Our Ref: FG/93/20/NMA

Non material amendment following grant of FG/124/19/HH to replace 2 roof light windows with dormer roof windows to match the existing dormer roof window granted.

10 Oval Way Ferring BN12 5RA

PROPOSED ELEVATIONS revision works lined red

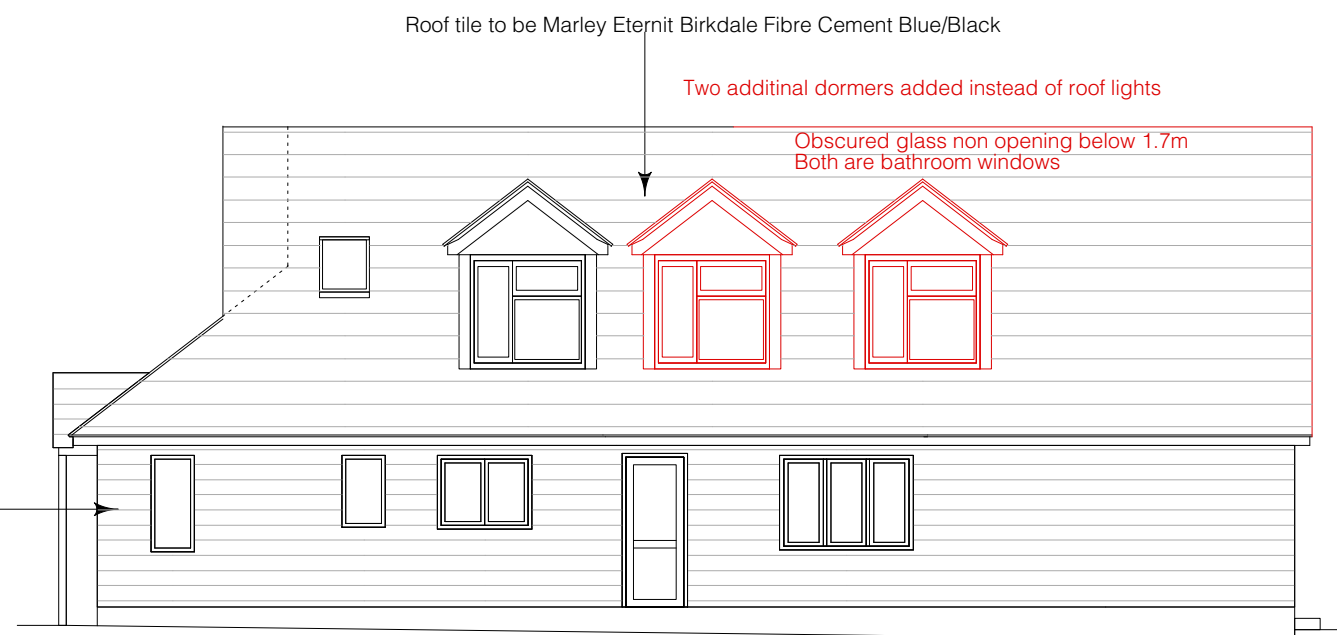
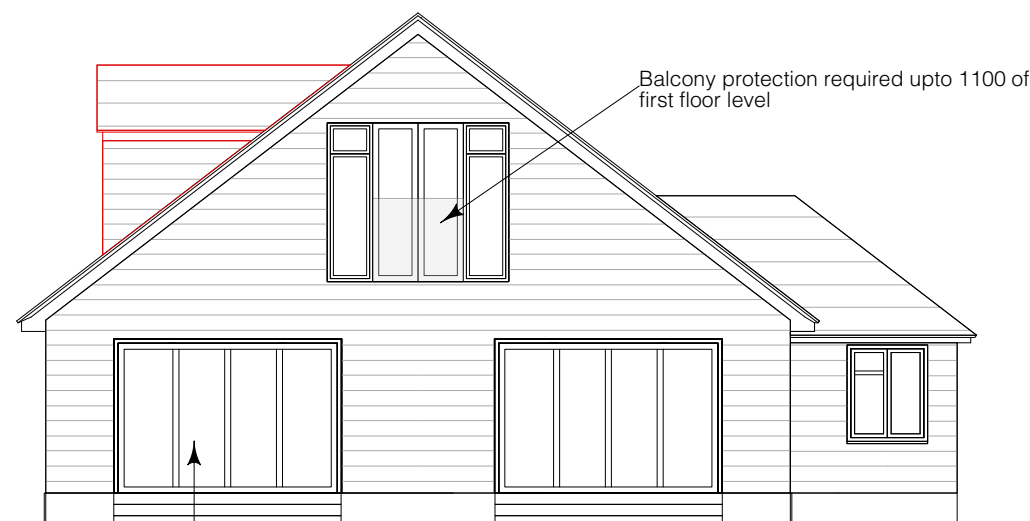
I refer to your recent application for a Non Material Minor Amendment. I note than you seek to replace two Velux rooflights with two dormer windows.

The reasons that these proposals have not been accepted as Non-Material Amendments is because the proposed changes alter the appearance of the dwelling and is of a scale that would not be accepted under this type of application.
